From: Amanda Scholes on behalf of Planning.Responses
Sent: 02 February 2022 09:17
To: Planning Scanning
Subject: FW: PO/16/21/DOC
Attachments: window profiles.pdf

Peckhams Poling Street Poling BN18 9PT

Approval of details reserved by condition imposed under ref PO/8/21/L relating to Condition No 2 - details of wood treatment and new windows and doors

TITLE
Proposed
Floor Plans &
Elevations
Site Plan

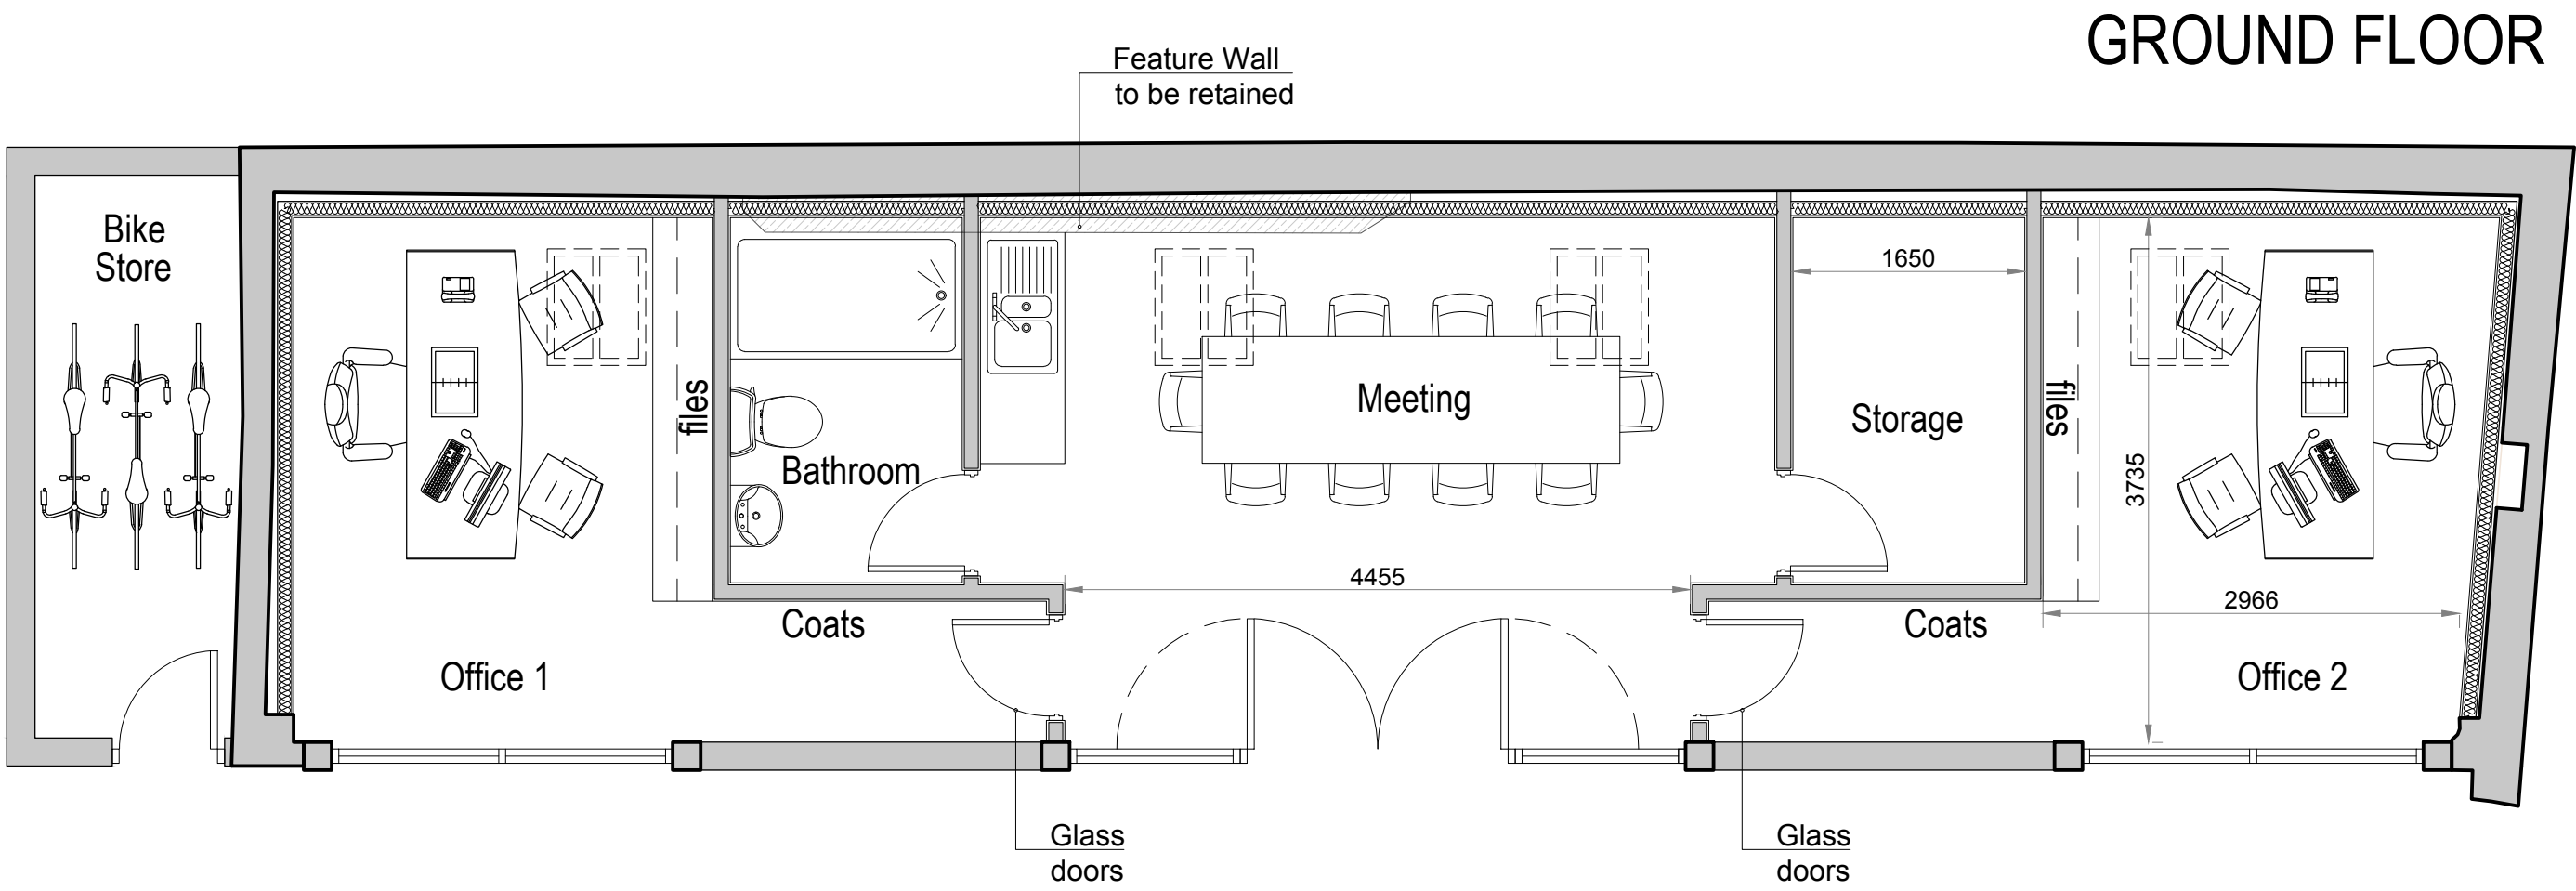
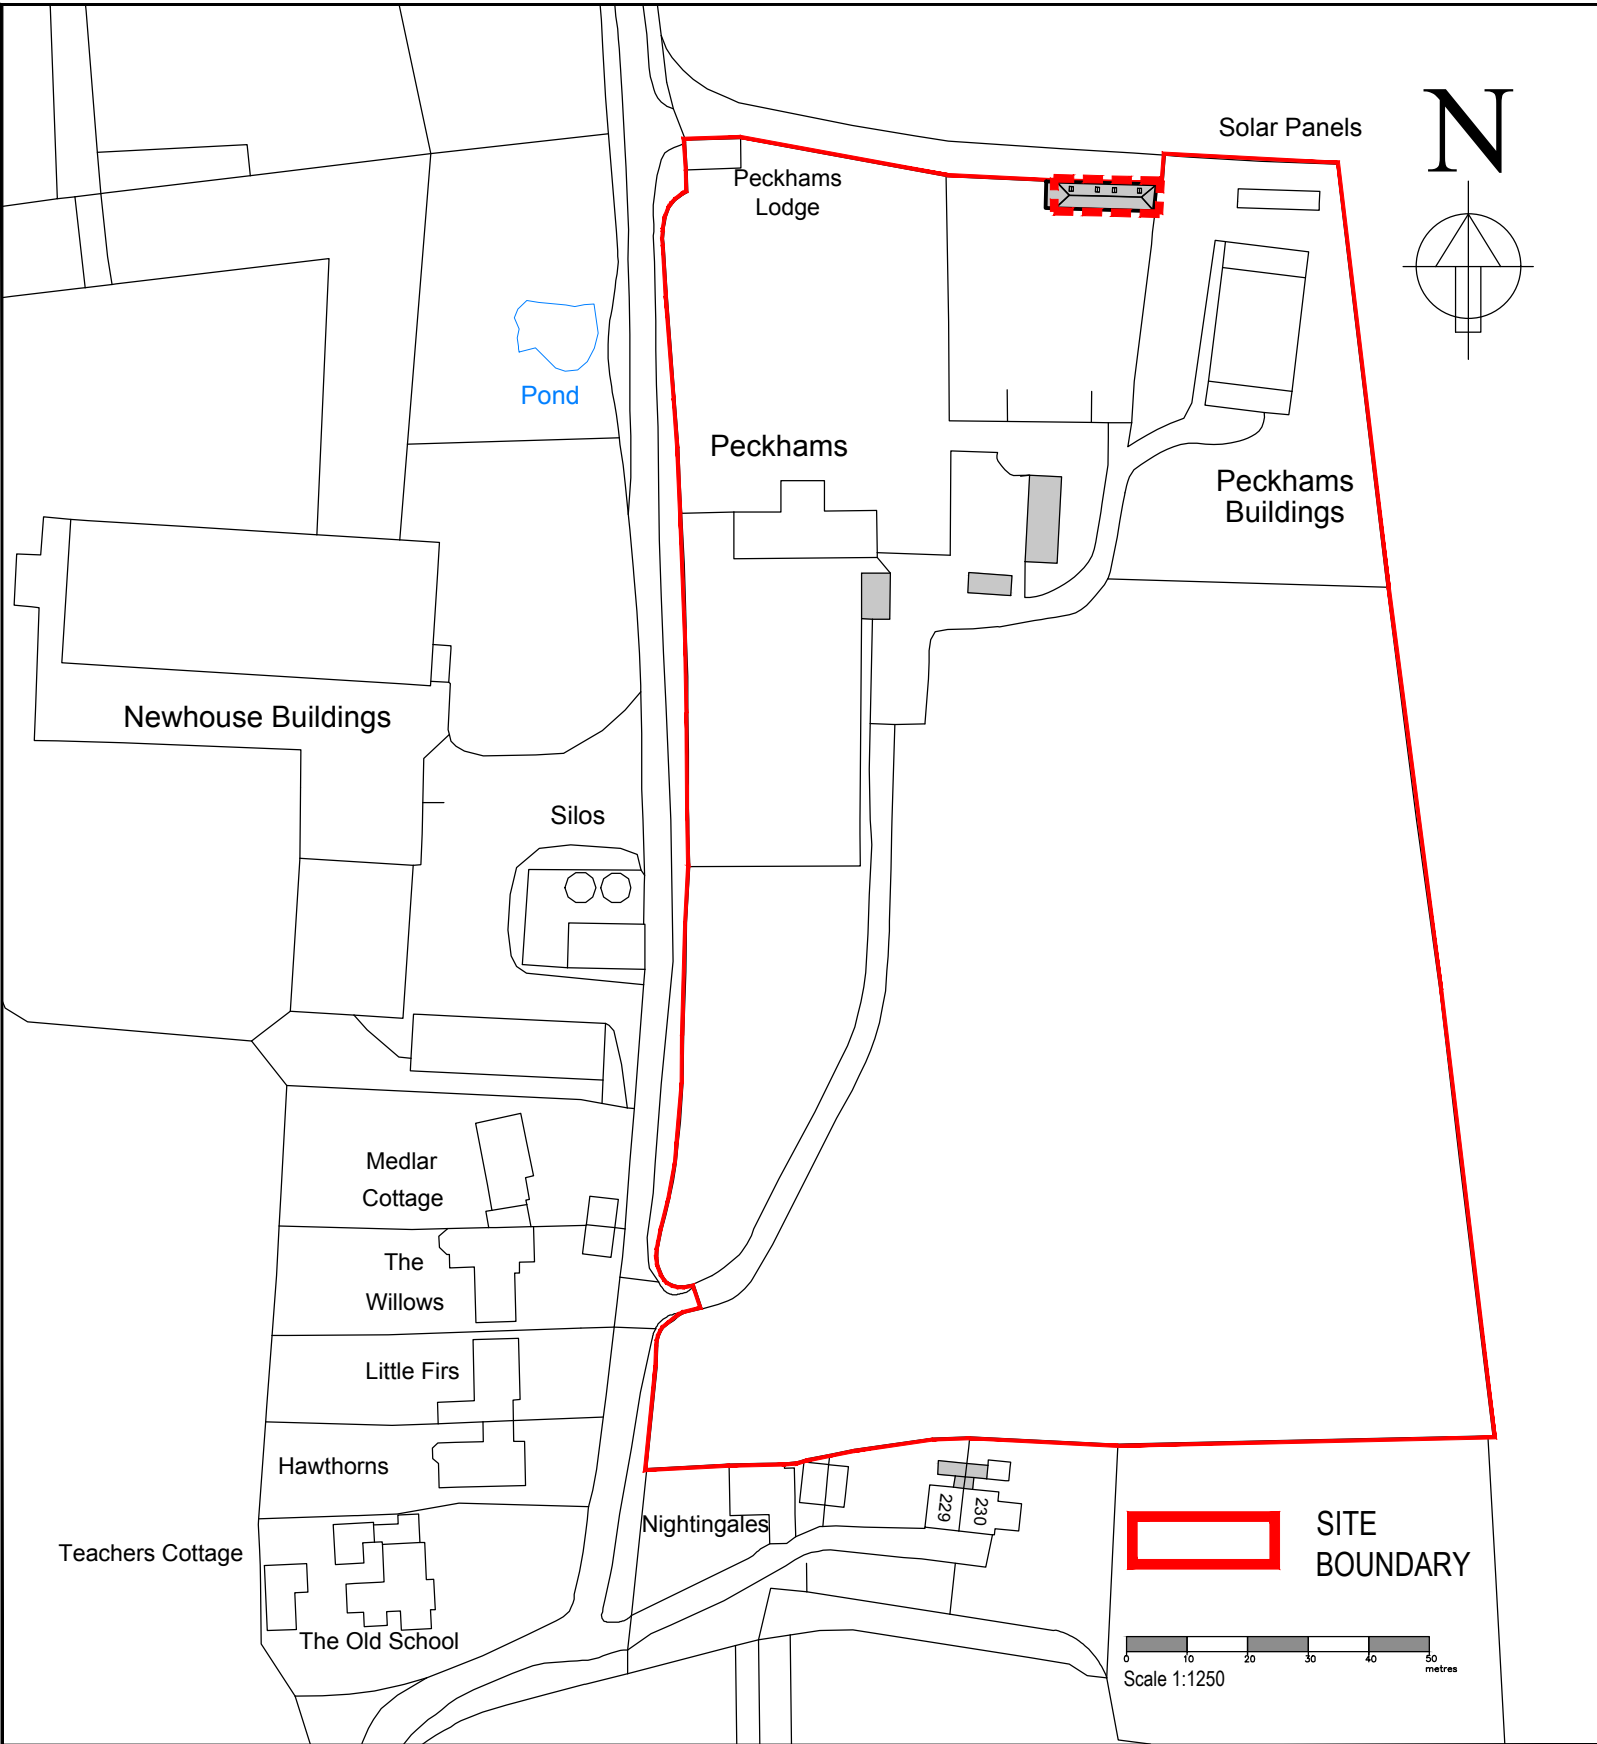
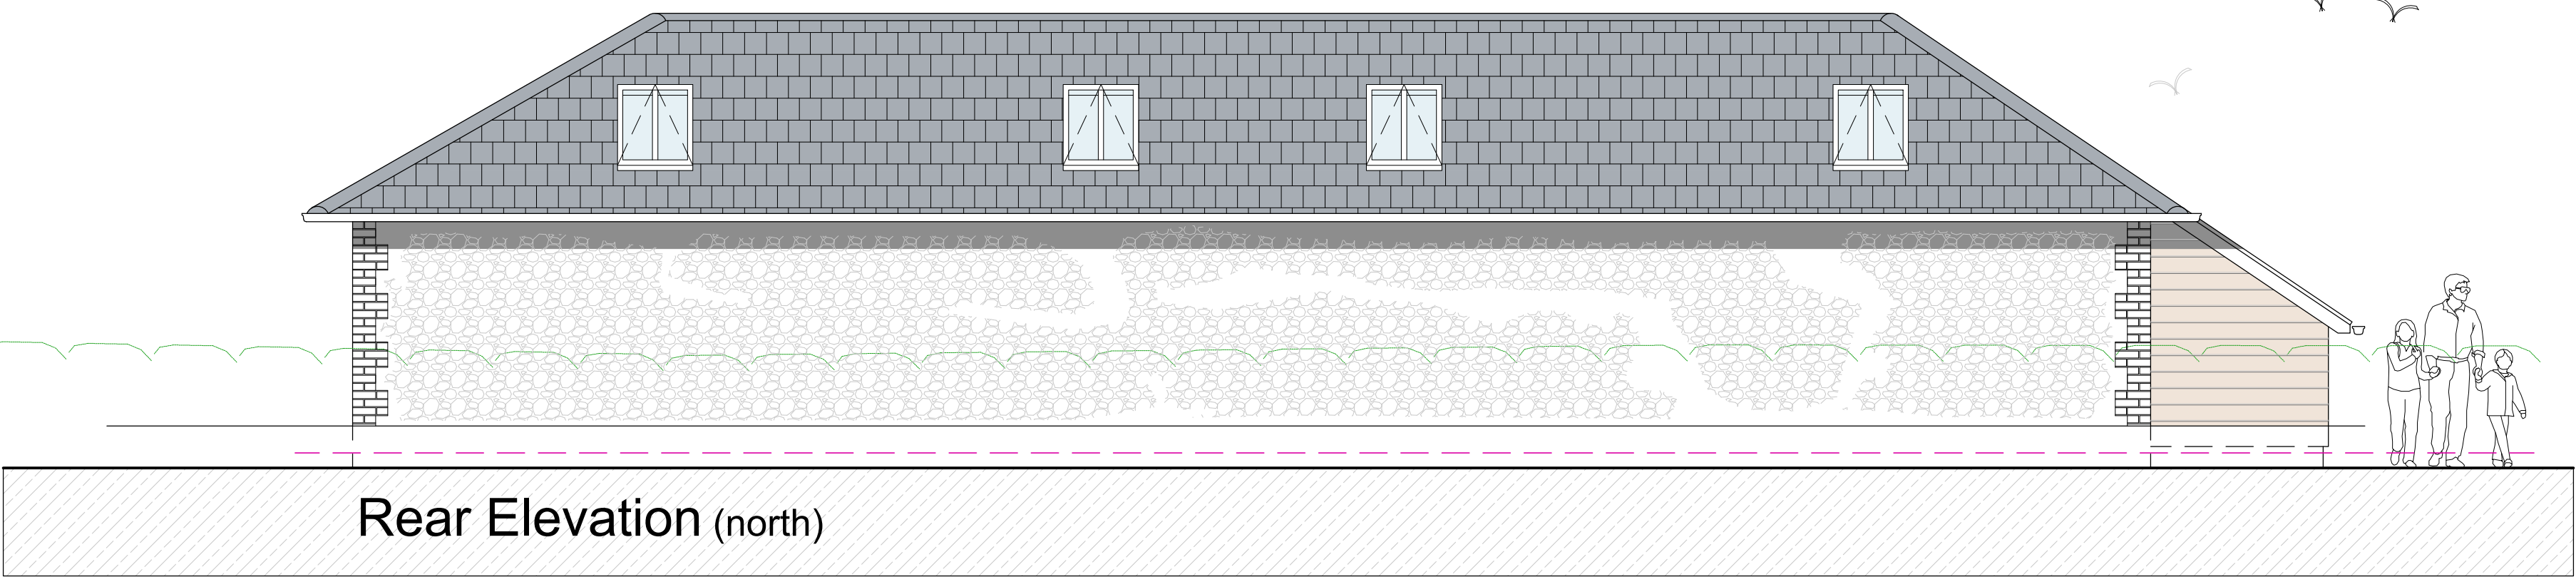
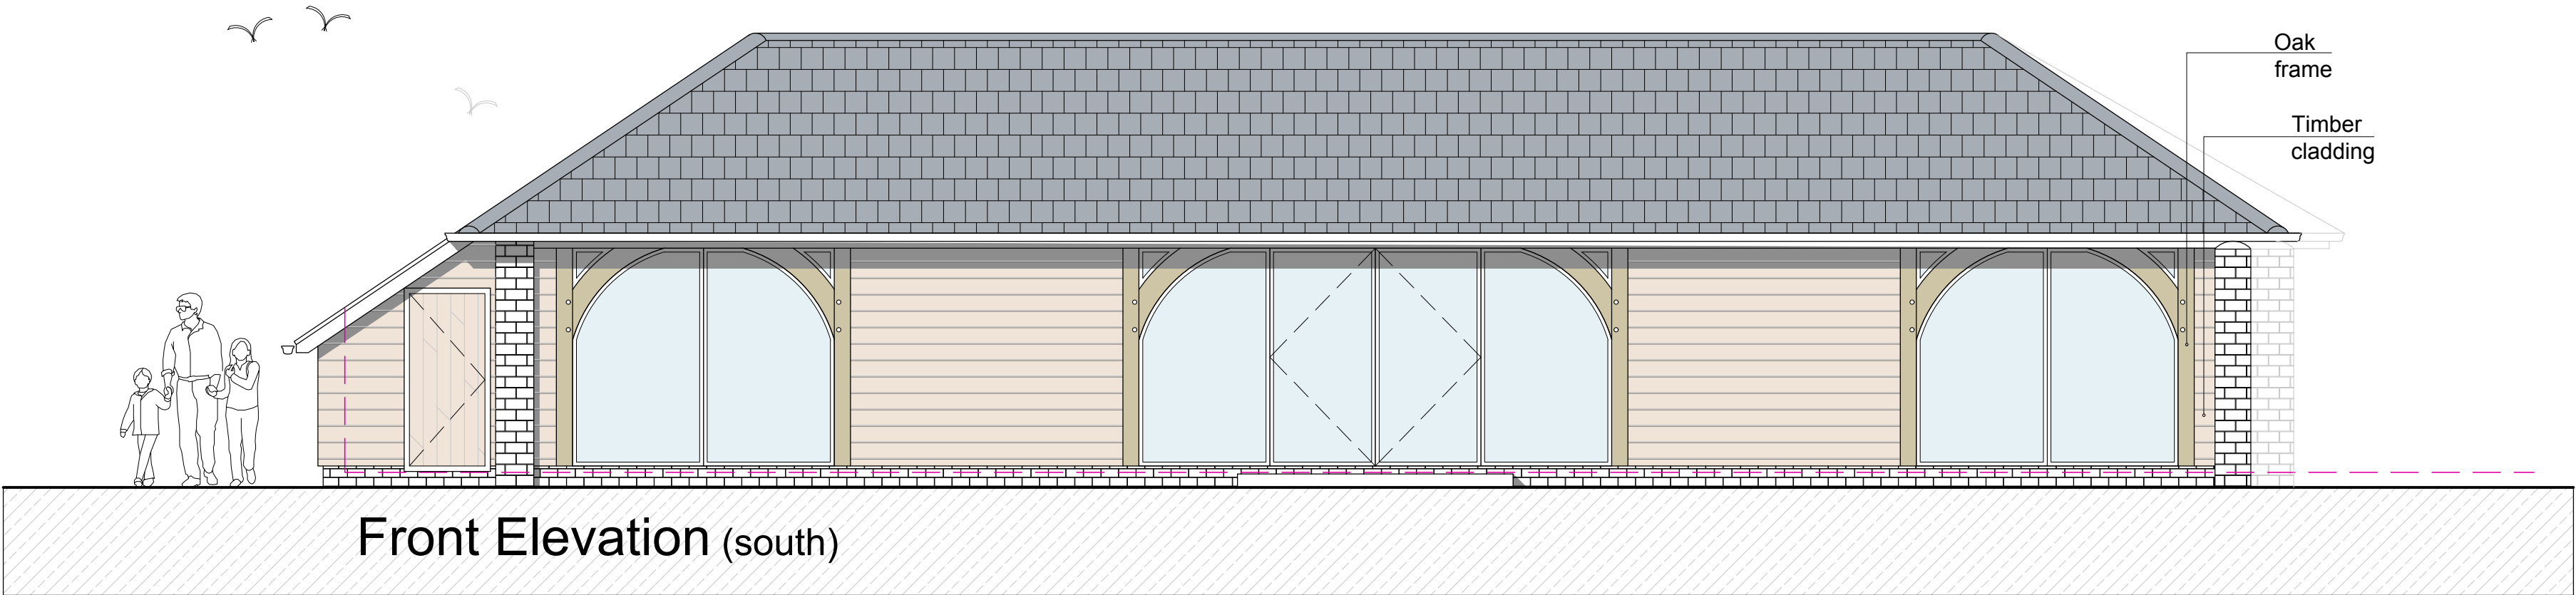
The proposed rooflights seem to be acceptable. However, the level of information regarding the windows is limited to two photographs. It would help to have sections of the sliding doors – which were not clearly displayed on the approved consent.

I have pleasure in attaching the section details for the sliding doors. It is desirable for these to be opening as this is a South elevation and such a large expanse of glass on each of these rooms with the only ventilation being limited to the roof lights which will make it extremely uncomfortable on hot sunny days.
